**SSD\_7081: DEVELOPMENT FOR FACULTY OF ARTS & SOCIAL SCIENCES (FASS), CAMPERDOWN CAMPUS**  
**UNIVERSITY OF SYDNEY RESPONSE TO SUBMISSIONS**

**OCTOBER 2016**

The University of Sydney has reviewed all submissions received during the statutory public exhibition period of State Significant Application SSD 7081 – *Faculty of Arts & Social Sciences building*, located on the northern edge of the University's Camperdown campus fronting Parramatta Road, south of campus Science Road, and east of the University's Ross Street entrance.

4 Awning Section 2  
SCALE: 1/188

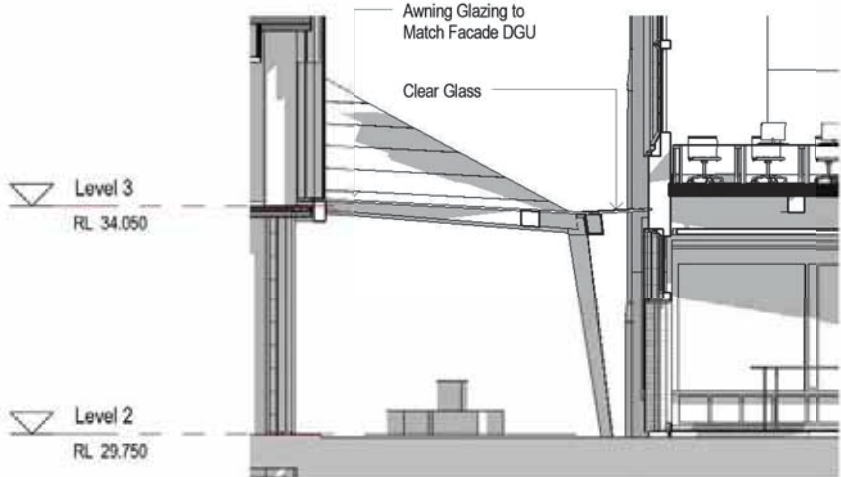
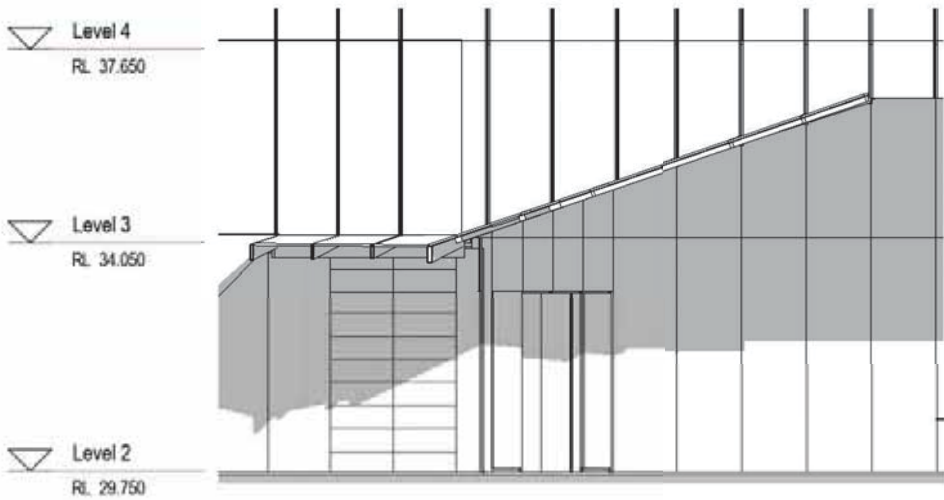
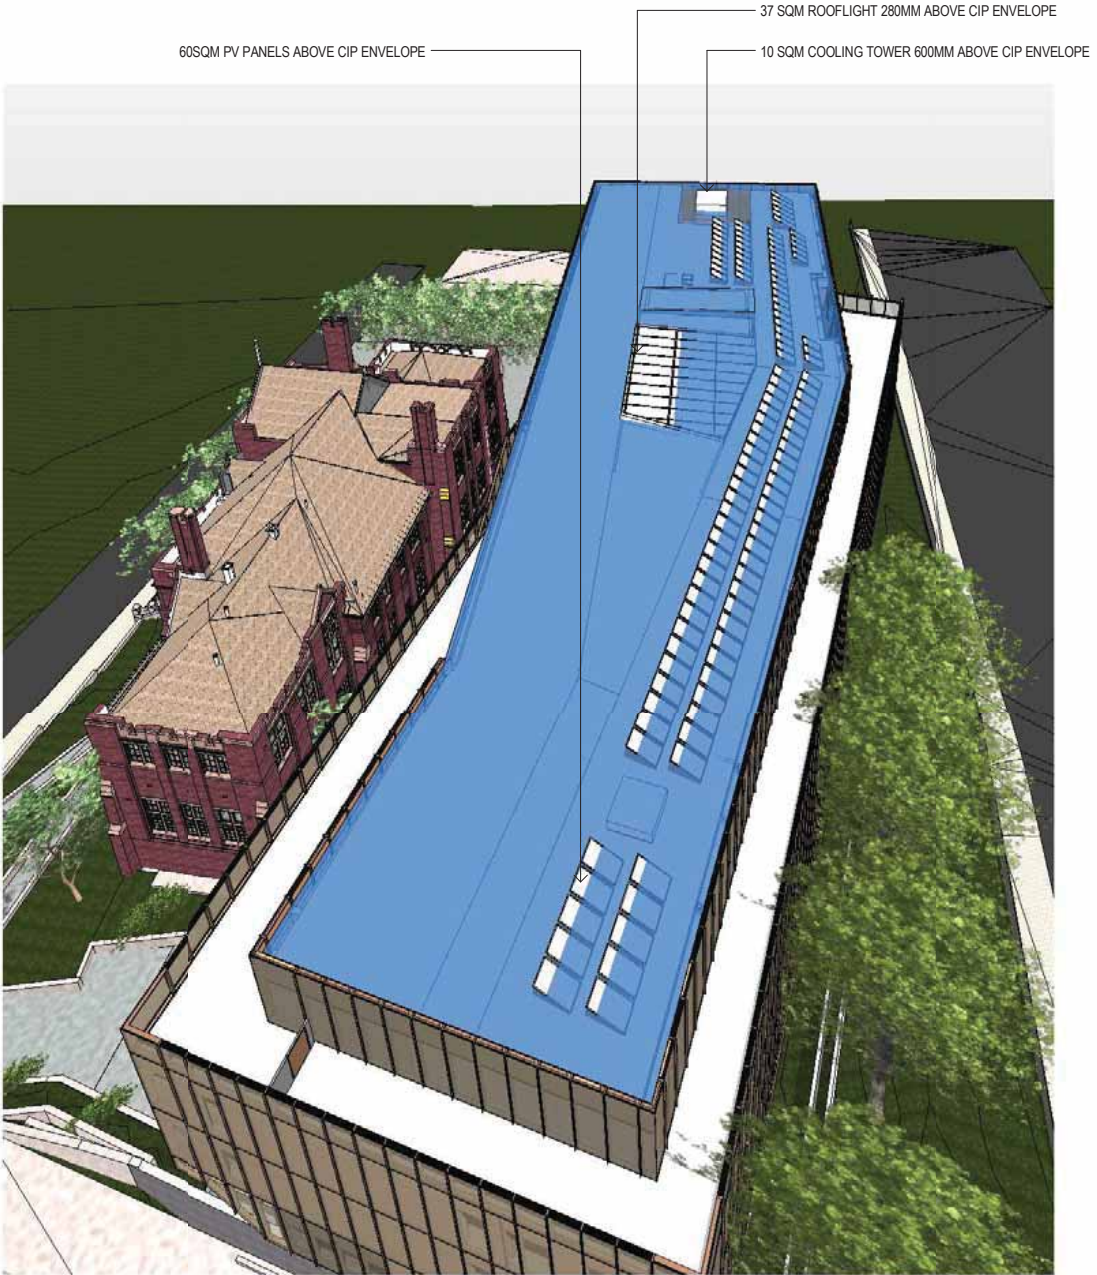
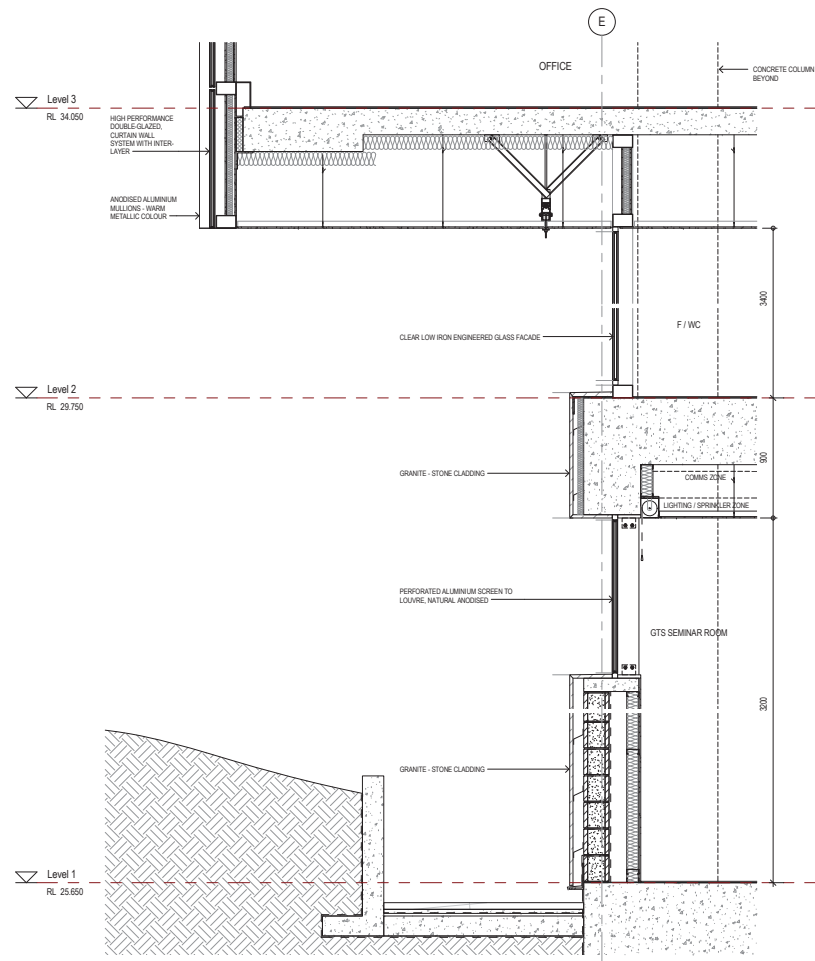
SSD 7081 – FASS BUILDING	
OGA RECOMMENDATIONS	USYD PROJECT RESPONSE
<p>5. Further detail of the <b>entry awning</b> is required to ensure no negative visual or material impacts on the R.D.Watt building.</p>	<p>The amended awning design between FASS and RD Watt presents the awning designed as a folded out plane from the warm mesh FASS façade supported on fabricated structural downpipes, located away from the RD Watt façade. A clear glazing plane continues the weather coverage to the RD Watt façade with a light wall connection to respect the heritage RD Watt masonry façade. Refer to SK306, extract below.</p>

SSD 7081 – FASS BUILDING	
OGA RECOMMENDATIONS	USYD PROJECT RESPONSE
	<p>The amended awning design therefore minimises physical connection and impact to the RD Watt building, with structural support provided independent of the heritage building, and only minimal intervention and fixing required to the heritage façade.</p> <p>The awning is contemporary and consistent with the façade articulation of the proposed FASS building, but its glazed materiality ensures minimal visual impacts to the northern façade of the heritage item.</p> <p>A Heritage Impact Statement was submitted with the application. The HIS supported provision of the awning in principle and the proposed detailed designs are consistent with the recommendations of the HIS, which required that the awning should be designed to be largely reversible (i.e. can be removed with minimal intervention or repair to the building fabric).</p>

1 Facade Section B1\_Part 01  
SCALE: 1:20

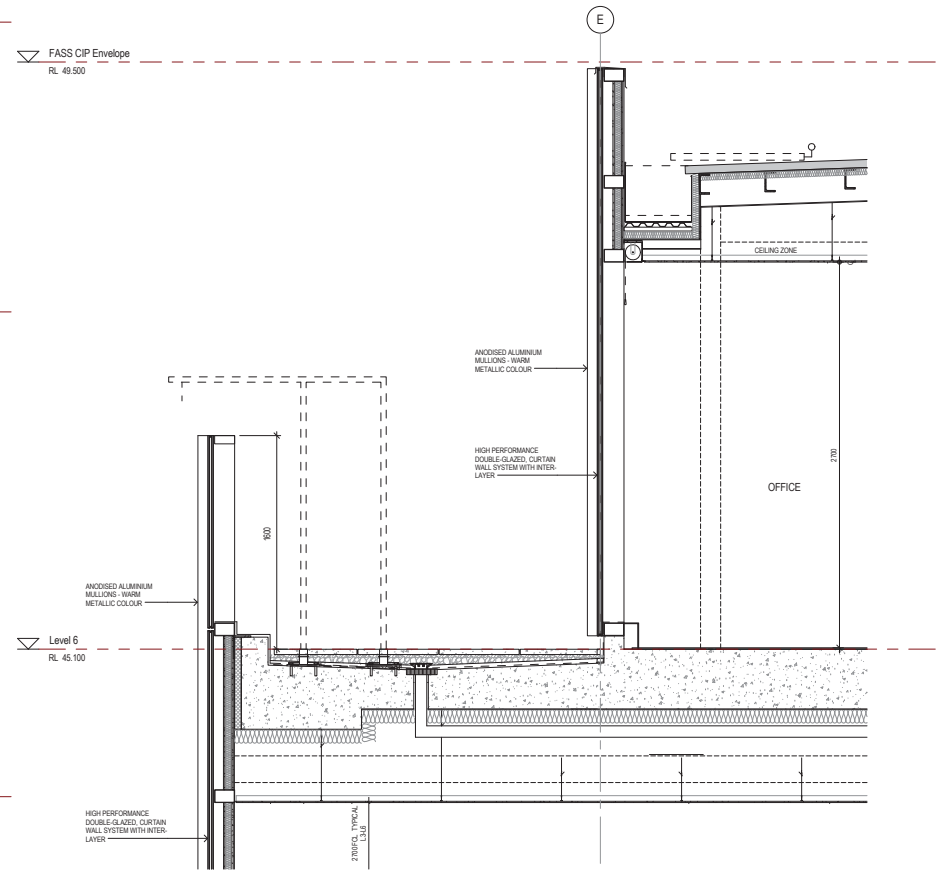
SSD 7081 – FASS BUILDING	
OGA RECOMMENDATIONS	USYD PROJECT RESPONSE
<p>4. Further information is required to assess the design excellence of the proposed <b>façade and 'warm interlayer'</b>. Submission of a sample board and 1: 20 typical cross sections is recommended.</p>	<p>The FASS façade has been designed as a warm coloured sophisticated skin comprising a simple well detailed, double glazed curtain wall system with integrated bronze coloured micro mesh interlayer and expressed mullion blades, which provides the thermal protection required and a warm coloured façade in response to the earthy masonry tones of the RD Watt Building. This façade will express itself differently throughout the day – shimmering in the sunlight and glowing after sunset.</p> <p>The facade provides the University with a robust and durable building which is low maintenance and will retain its visual presentation over a long period of time. Refer to 1:20 typical North Façade Section drawing SK-410.</p> <p>The image below is a reference building Europaallee in Switzerland which illustrates a similar warm façade expression albeit in gold, whereas the FASS building façade finish will be in bronze.</p>

SECTION / ELEVATION AA  
SCALE 1:50 @ A1

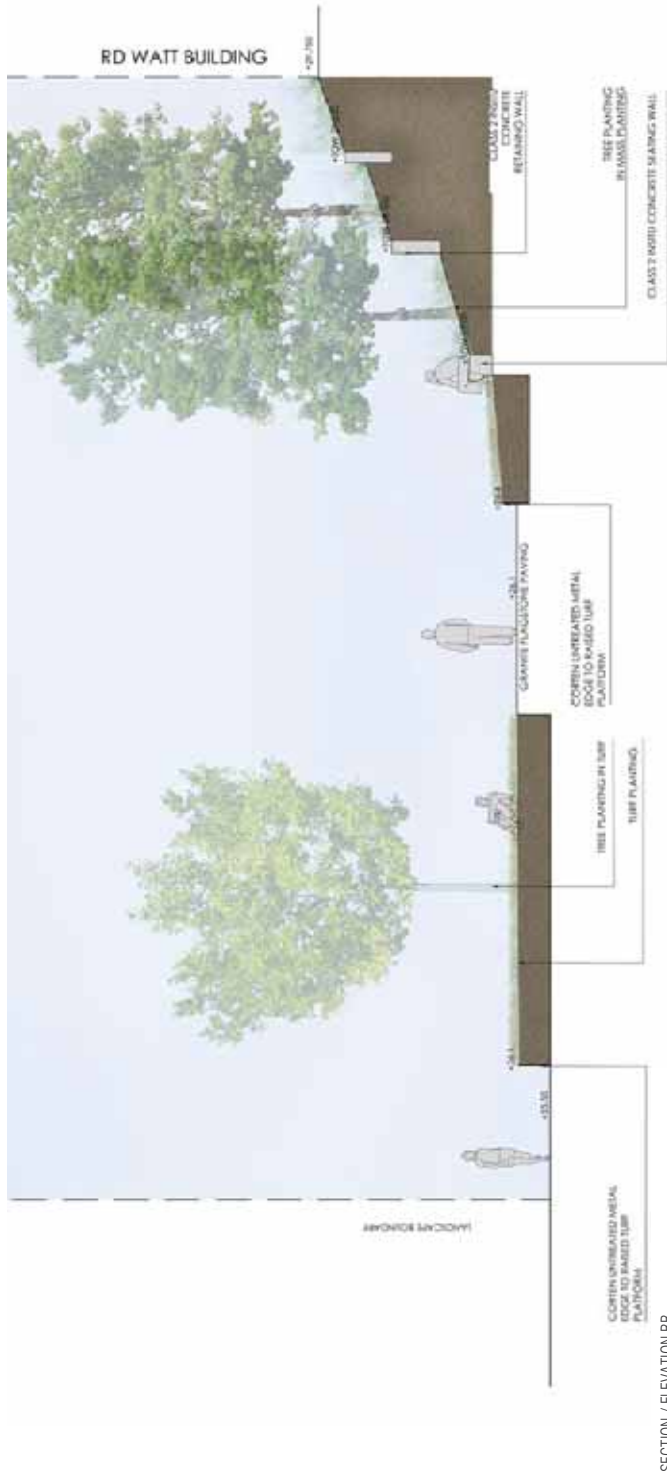
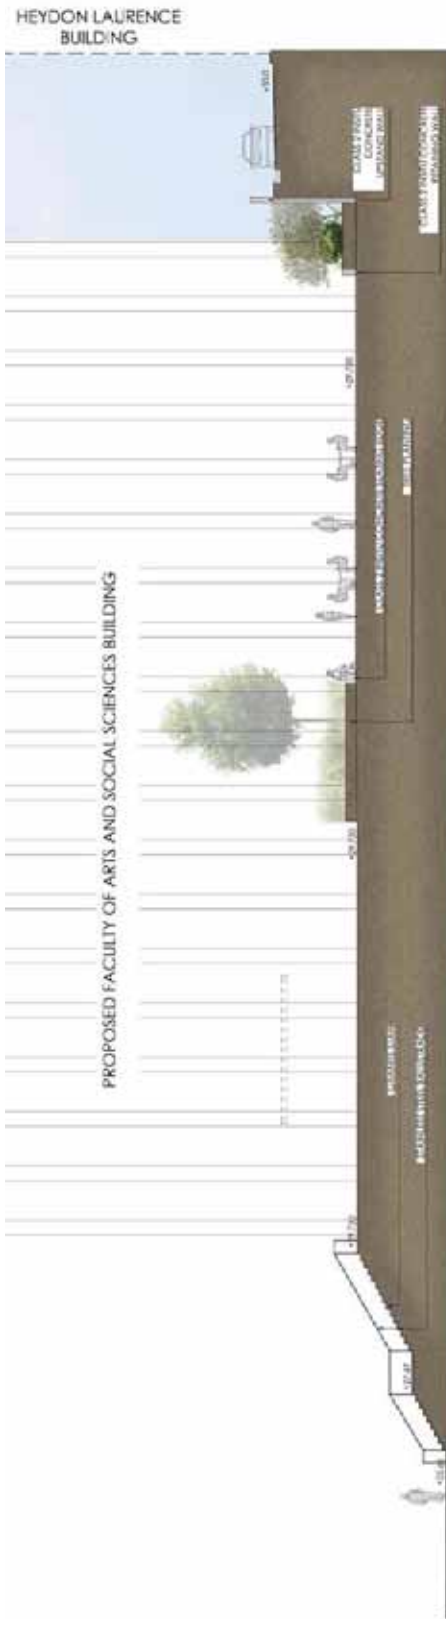
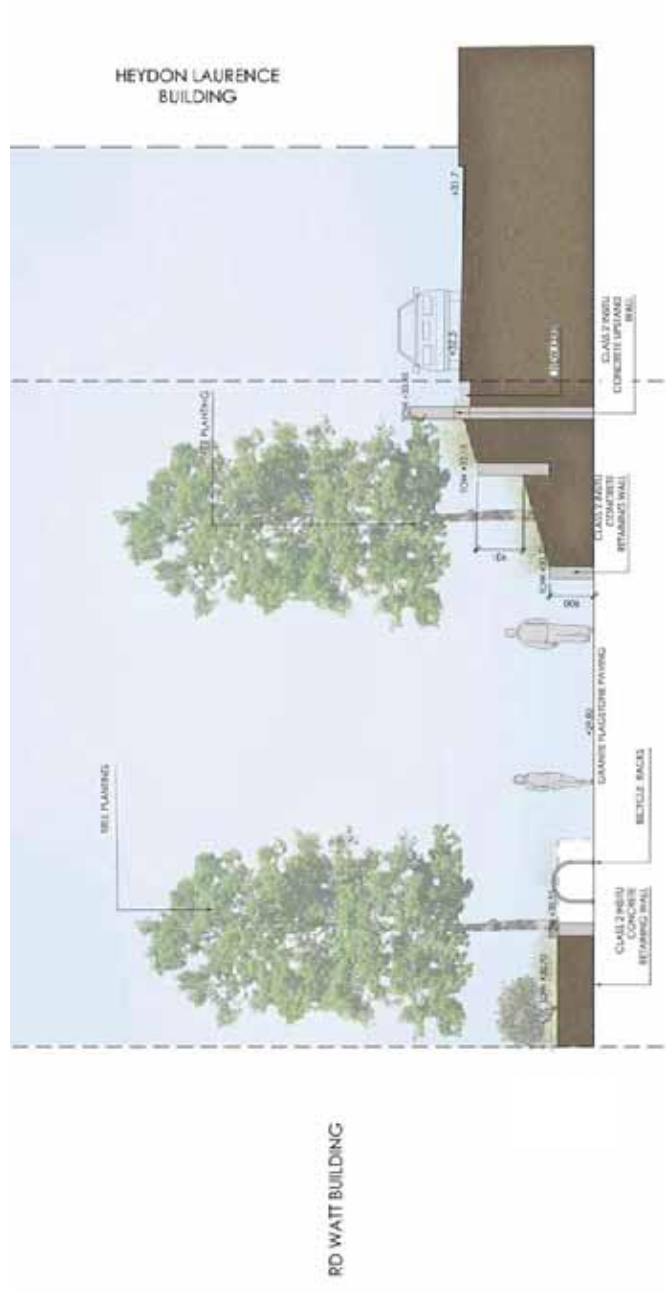
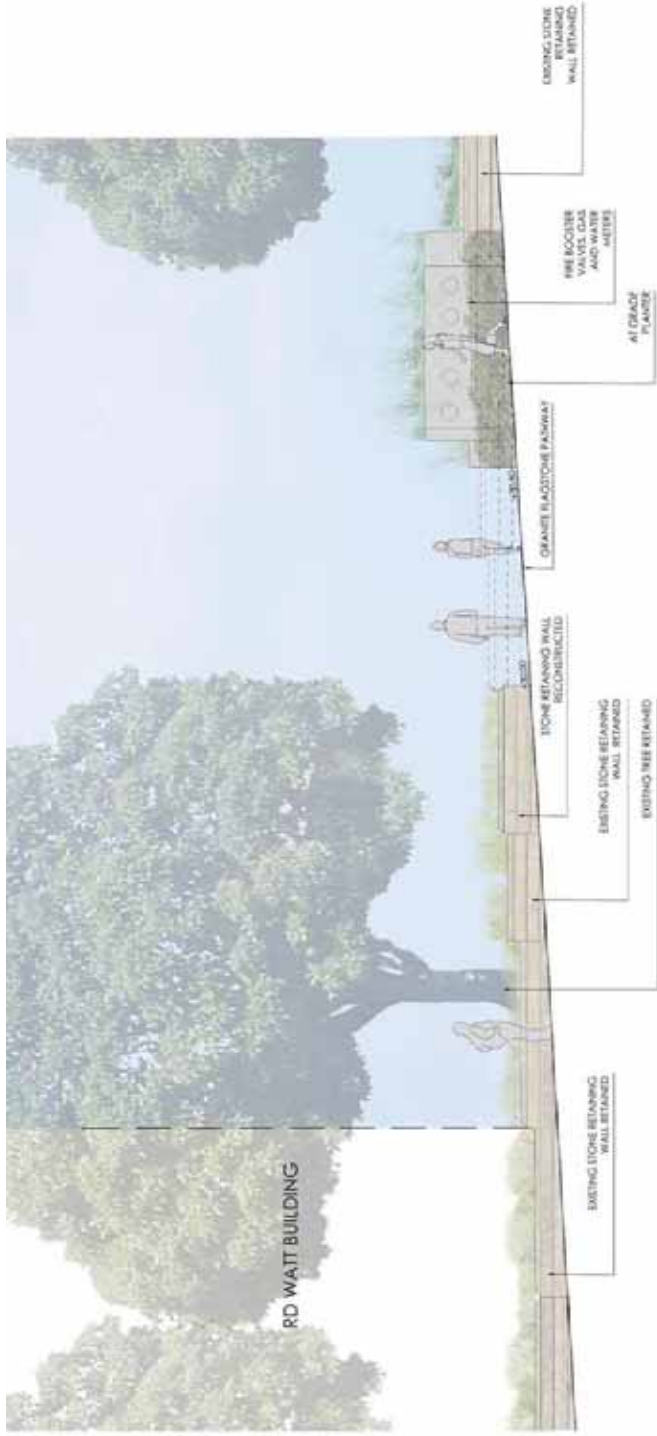
<p>5. Opportunity exists to better integrate the landscape and public domain interface between the proposed development and the existing Heydon-Laurence Building to the east. Further, the approximate three metre high retaining wall proposed along this common boundary would limit any future potential to easily link the public domain of the adjoining sites.</p>	<p>Reference is made to the Clouston Concept Landscape Plan (refer to plan extract illustrated in item 3 above) showing the intent for the courtyard as a pedestrian connection. The plan defines the courtyard space between FASS &amp; RD Watt as opportunity to develop spaces for student congregation and waiting area for classes.</p> <p>Science Road provides the principle pedestrian connection between Heydon-Laurence, RD Watt and other existing buildings whose collective entry points are off Science Road. The lane to the west of Heydon-Laurence building is a back of house maintenance road frequently occupied by trucks and delivery vehicles both to the building and the switch room to the rear (north) of the building. The Heydon-Laurence building does not provide any active or functional address or use to this service laneway. Nor are there any University plans to alter this arrangement.</p>
